DELEGATED DECISION TO DETERMINE PLANNING APPLICATIONS

Reference No: 2020/62/91711/W

Site Address: 56, Holly Road, Thornton Lodge, Huddersfield, HD1
3SE

Description: Erection of single storey and first floor rear extensions
and front and rear dormers

PROPOSED FIRST FLOOR

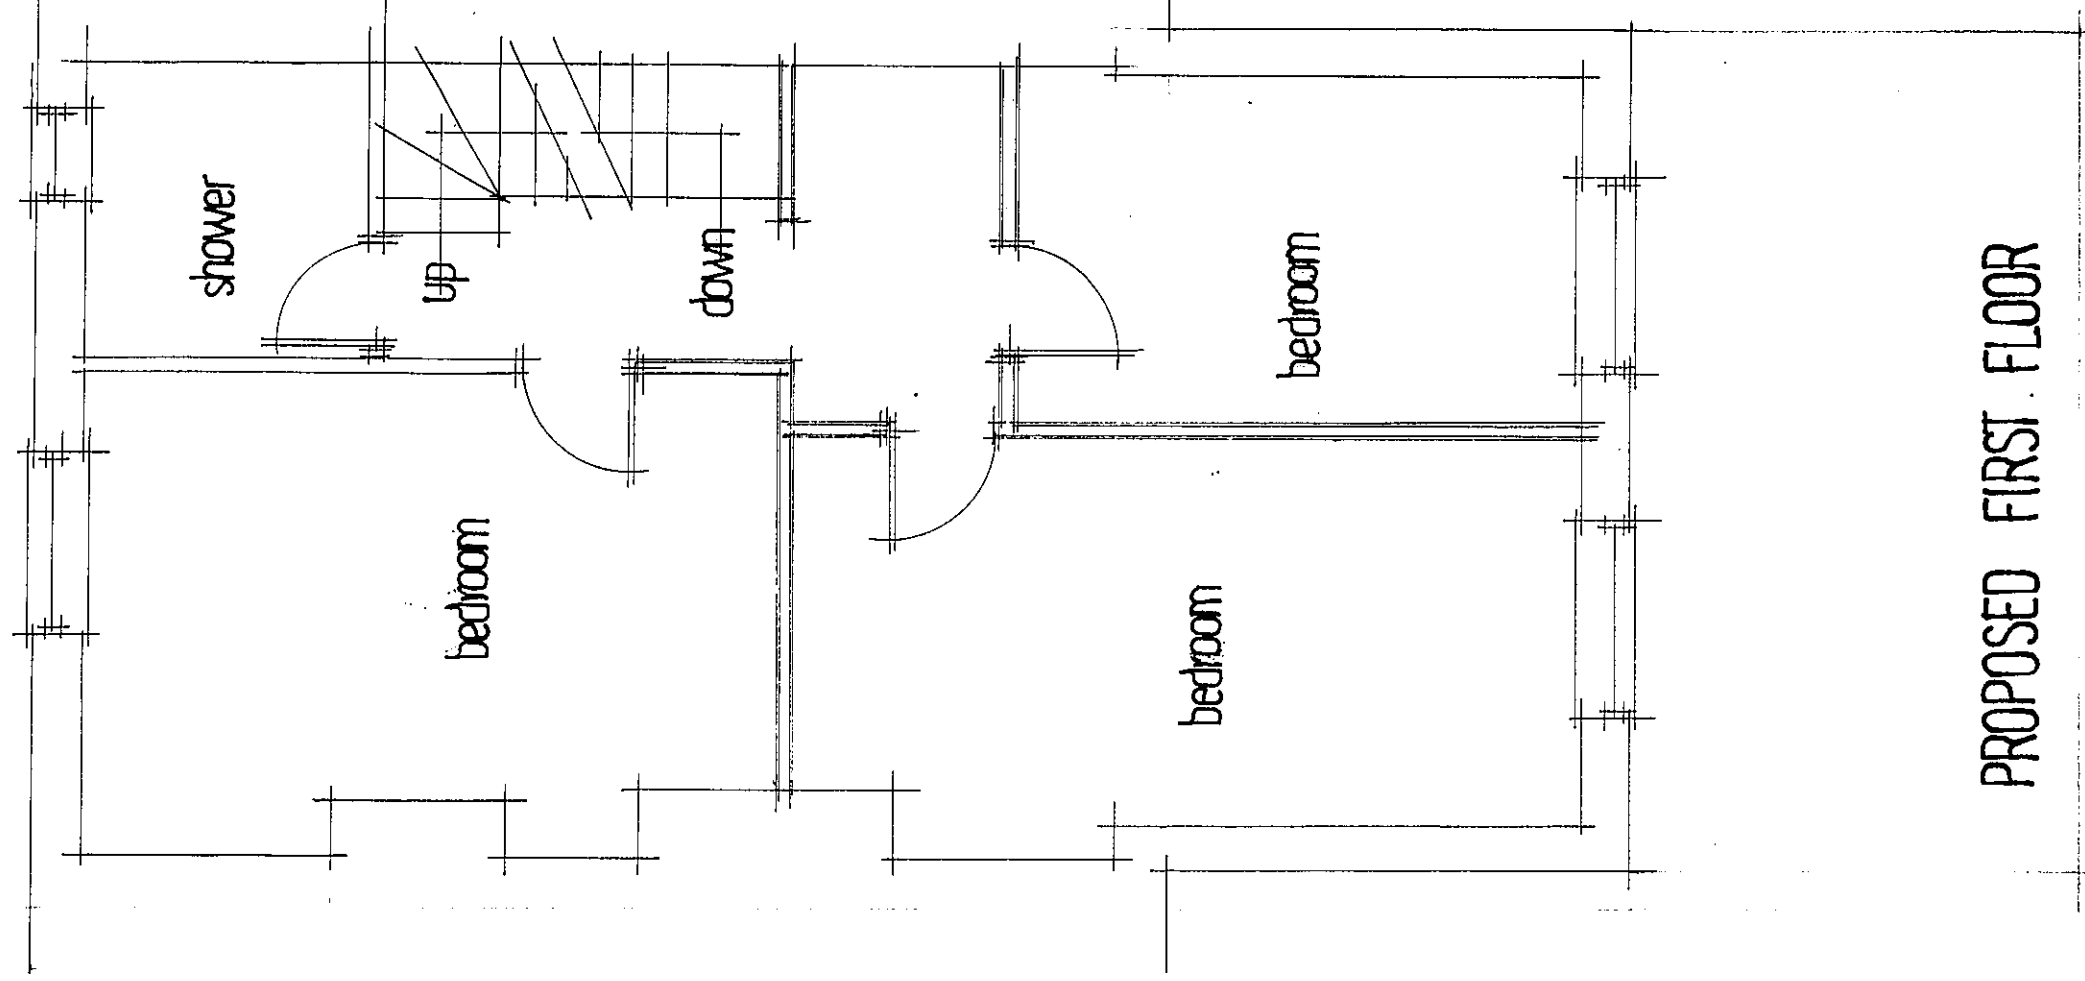
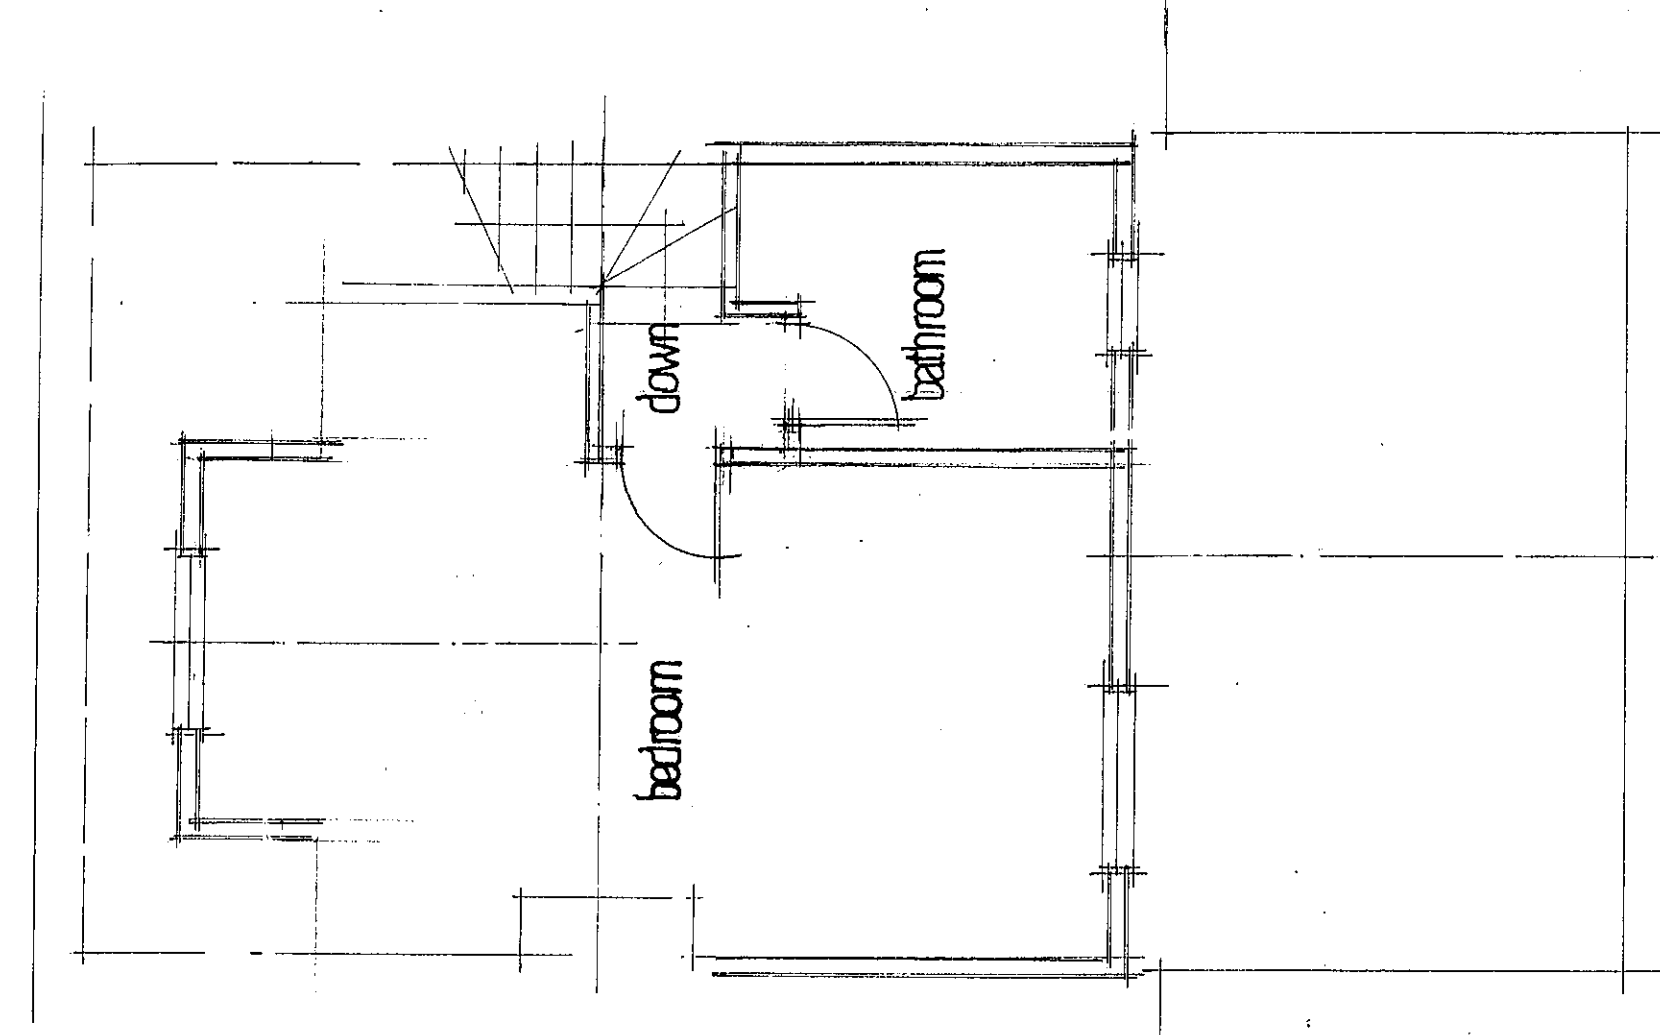
Slight concerns were raised with the applicant's agent about the lack of on-site vehicular parking therefore the applicant's agent amended the plans so that no additional bedrooms were proposed. These plans were received on 14th October 2020 and addressed the initial concerns raised.

No parking is provided on site, but the proposal would not result in the creation of another bedroom. Whilst it is noted that the bedroom in the roof space could be divided into two bedrooms, these bedrooms would be relatively modest and it is questionable as to whether this would result in additional pressure on parking in the locality. Further to this, the site is considered to be located within a sustainable location close to services and facilities, bus routes and Lockwood railway station, thereby reducing the need to travel by private car.
